December 19, 2023

Project No. 23001

**Re: SUB23-006 (LNL Builds, LLC Lot Line Revision)
Notice of Incomplete Application
2424, 2430, and 2436 74th Ave SE**

NEW LEGAL DESCRIPTIONS:

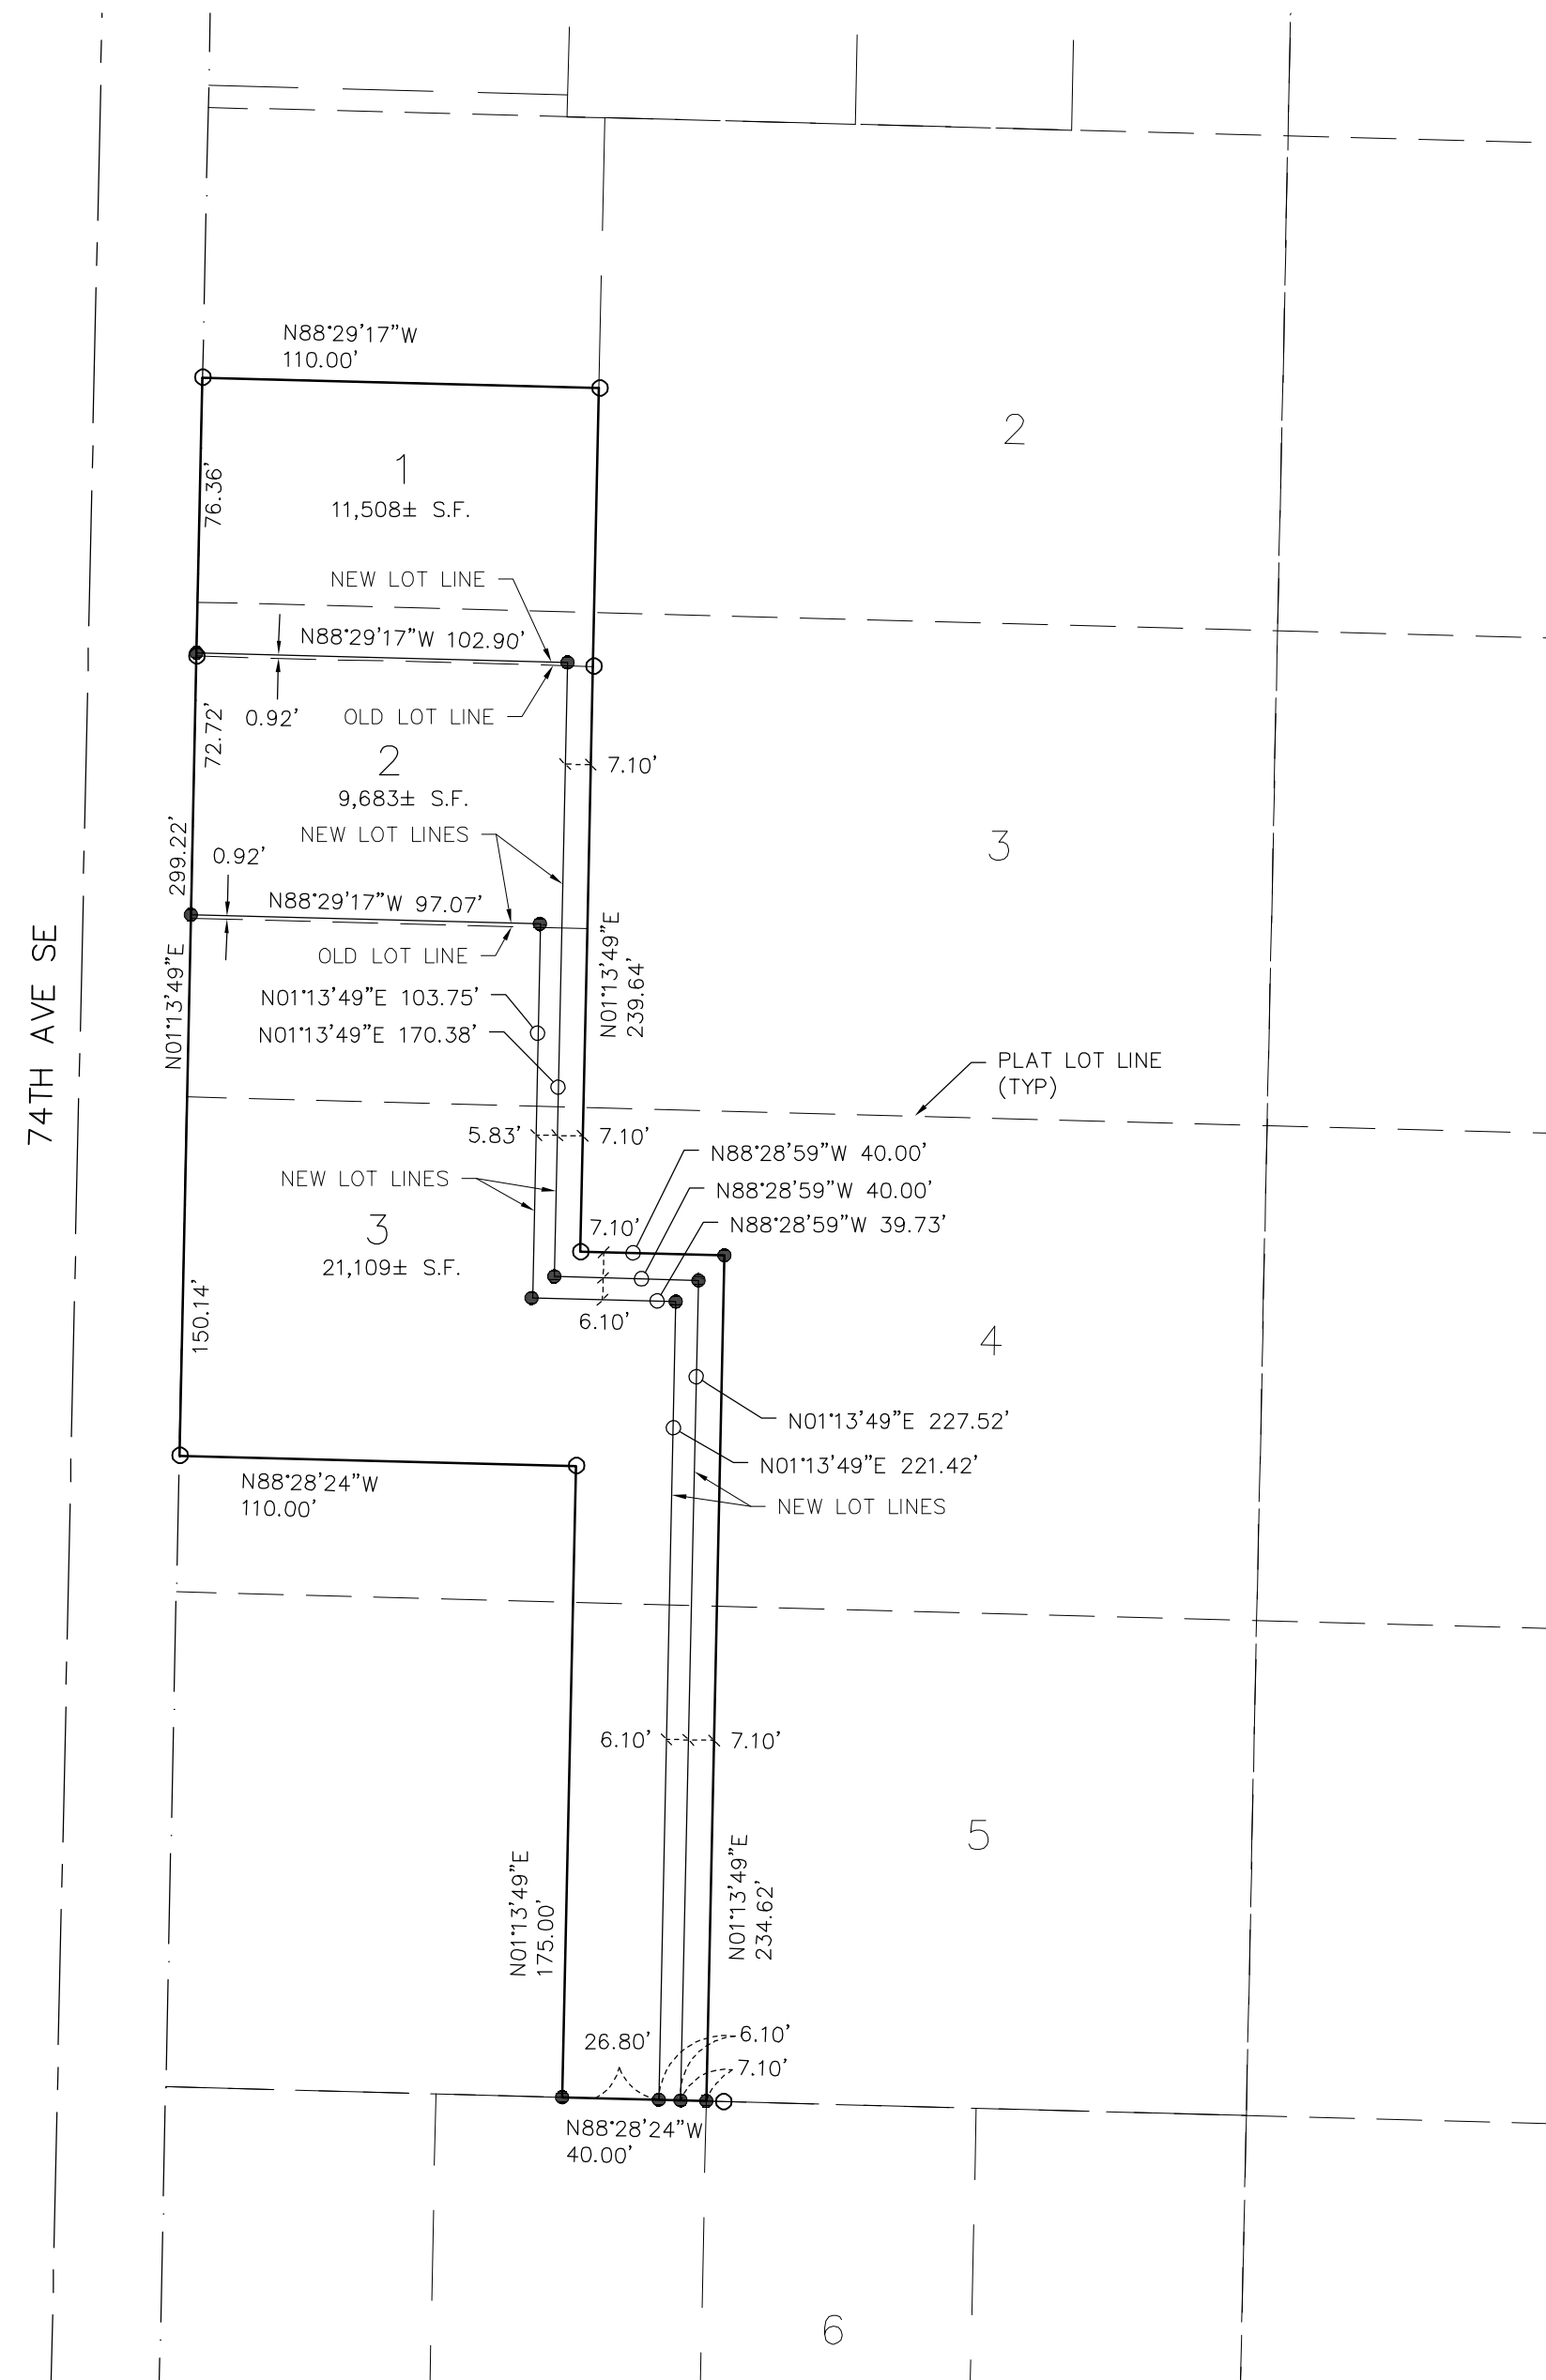
3. The City of Mercer Island GIS shows that 2436 74th Ave SE (parcel number 531510-0455) is encumbered by a wetland. The proposed property lines are proposed to cross the mapped wetland. Please provide a critical area report, prepared by a qualified professional, that addresses the proposal's impacts on the wetland and how the proposal complies with the standards of MICC 19.07.190.

Critical Area Report and Army Corps of Engineers response to wetland fill is provided.
